Recommendation Report for Planning Permission for Works or Extension to a Dwelling

REF NO: M/109/18/HH

LOCATION: 9 Ancton Close
Ancton
Middleton-On-Sea
PO22 6ND

PROPOSAL: Replacement detached garage.

PROPOSED GROUND FLOOR PLAN

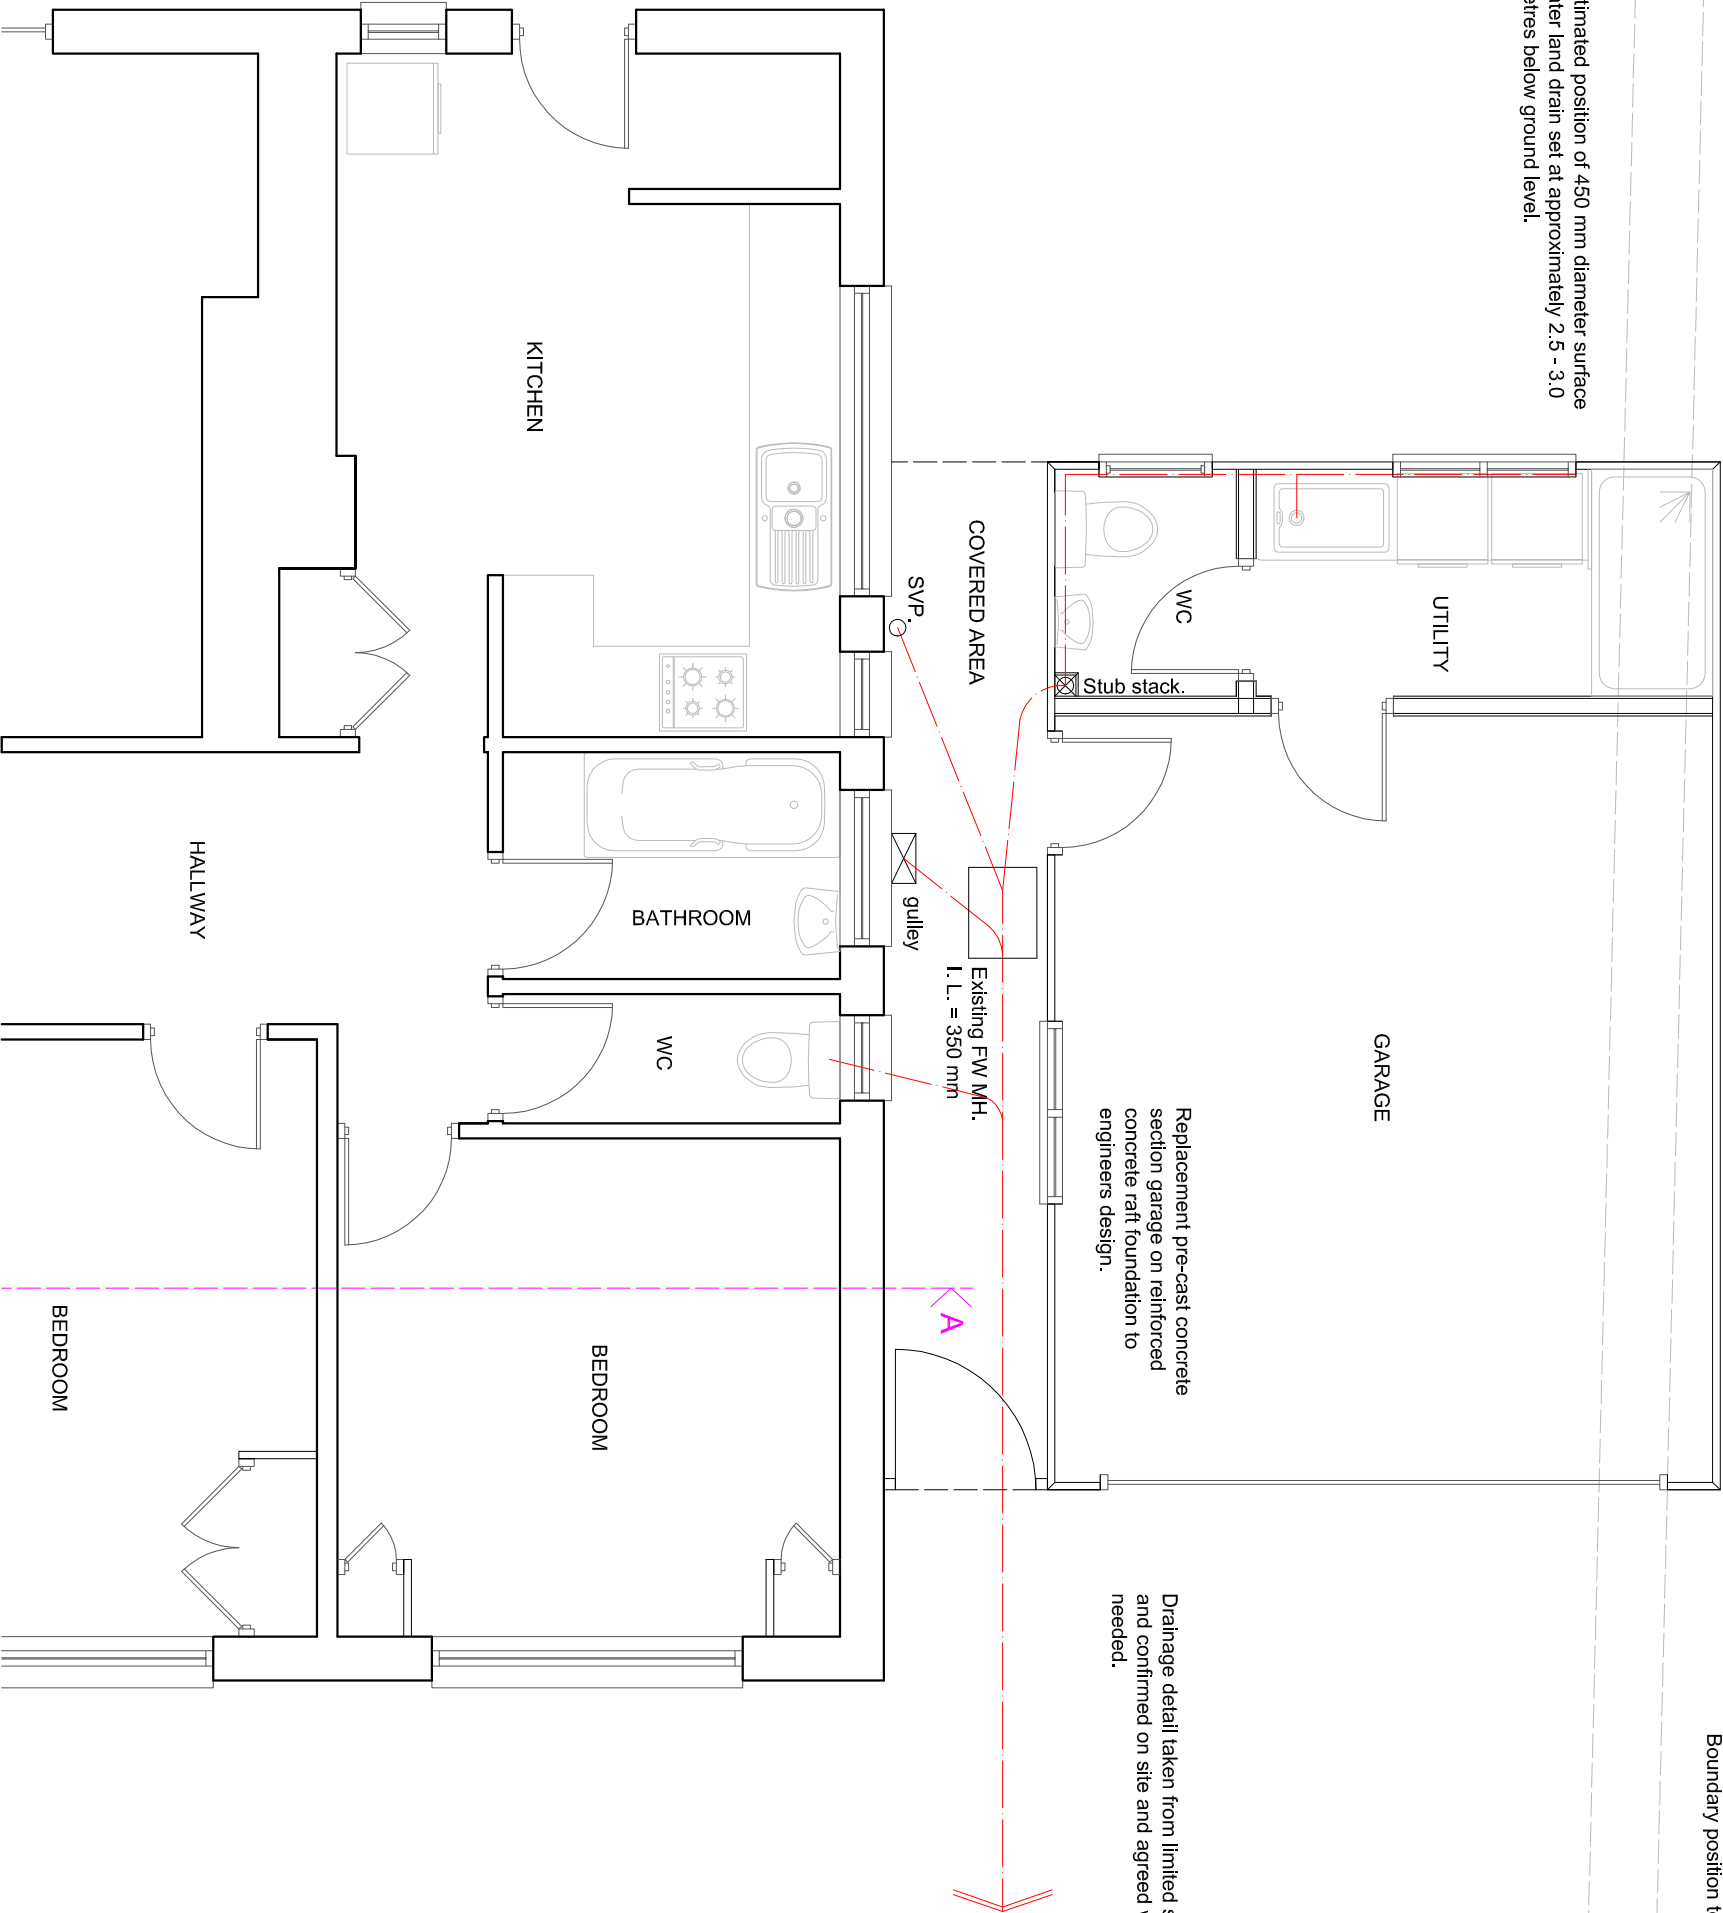
Drainage Engineers:
There is a 300mm diameter culverted ordinary watercourse running under the existing garage and the proposed structure.

Our byelaws state that no development should occur over or within 3m of an open or culverted ordinary

watercourse. However, as the application is for a replacement structure agreement will hopefully be made in this instance. In order for the development to be permitted the developer must demonstrate that the replacement structure will not place any load onto the culvert and that maintenance will be able to be carried out by the riparian owner.

PROPOSED ELEVATIONS

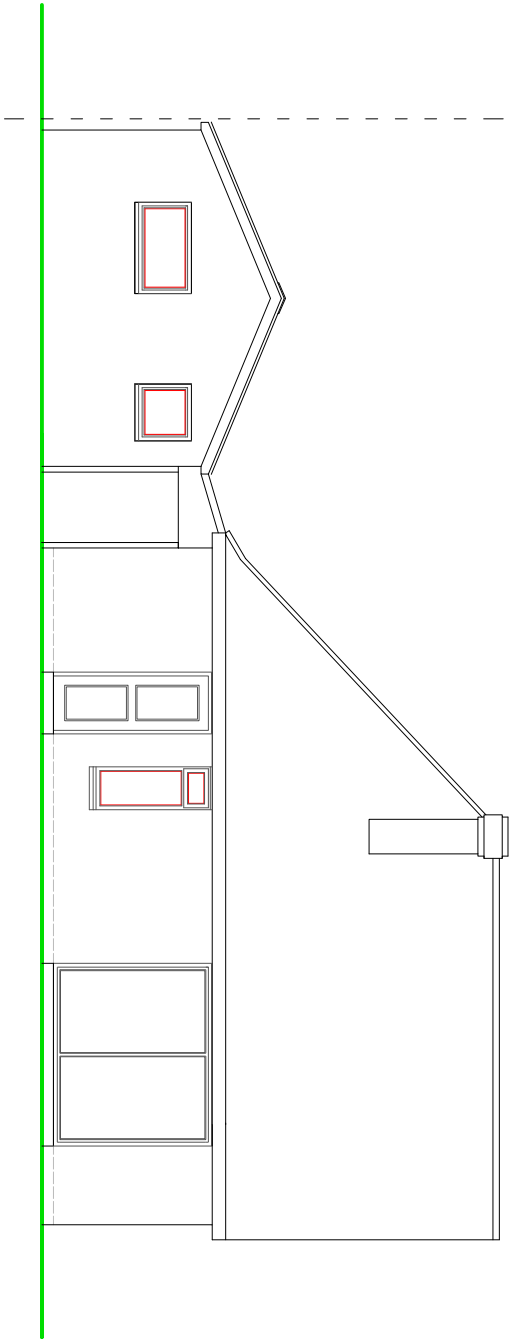
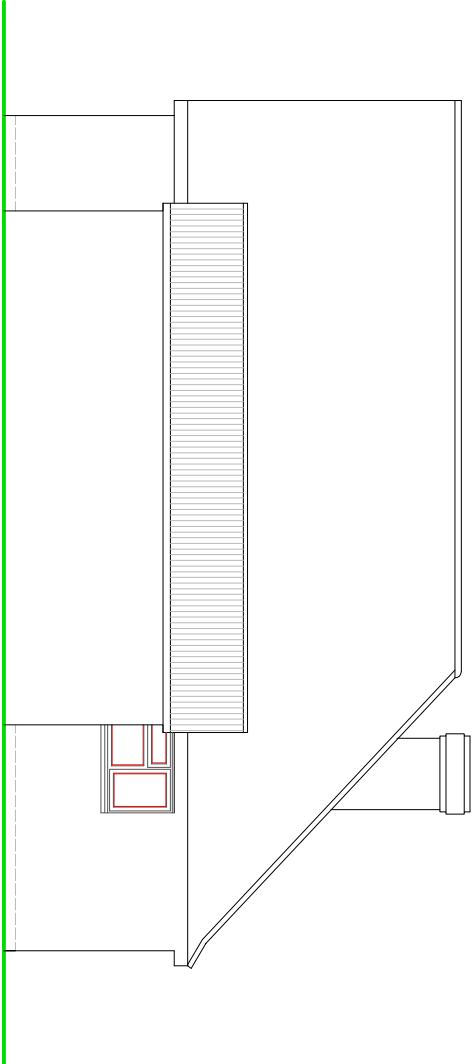
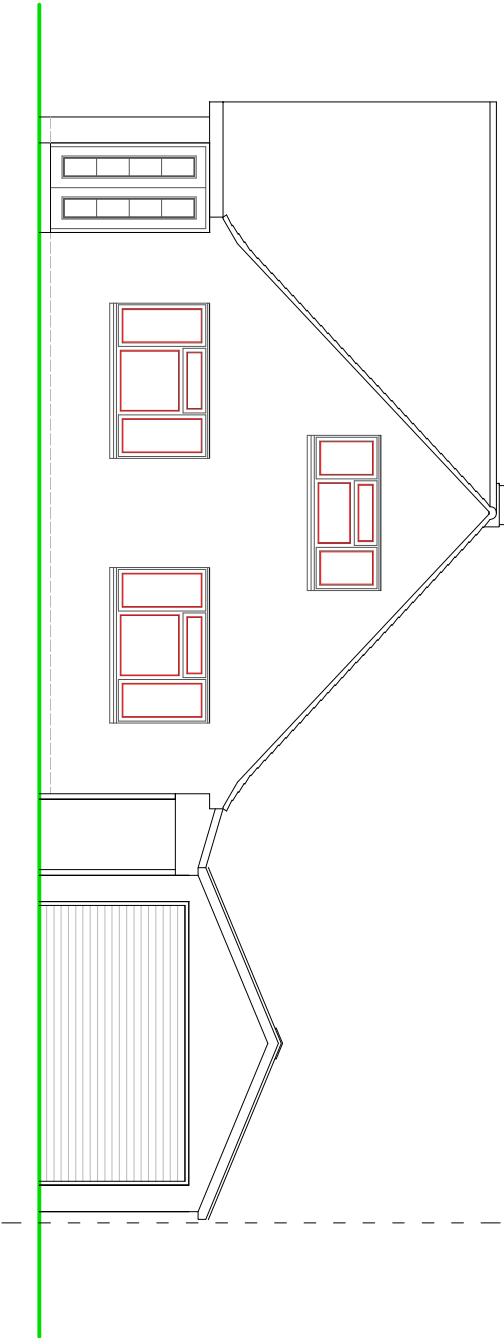
The proposals maximum height is 3.1m however, this is set 2.3m from the Eastern boundary of the application site, this is also 2.9m lower than the ridge height of the host dwelling, and is therefore not deemed to give rise to any significant adverse impact on neighbouring residential amenity. There is not considered to be a significant loss of privacy as the proposal features no windows on its Eastern elevation, and even if there were, any views would be impeded by the fencing that lies between the two properties.
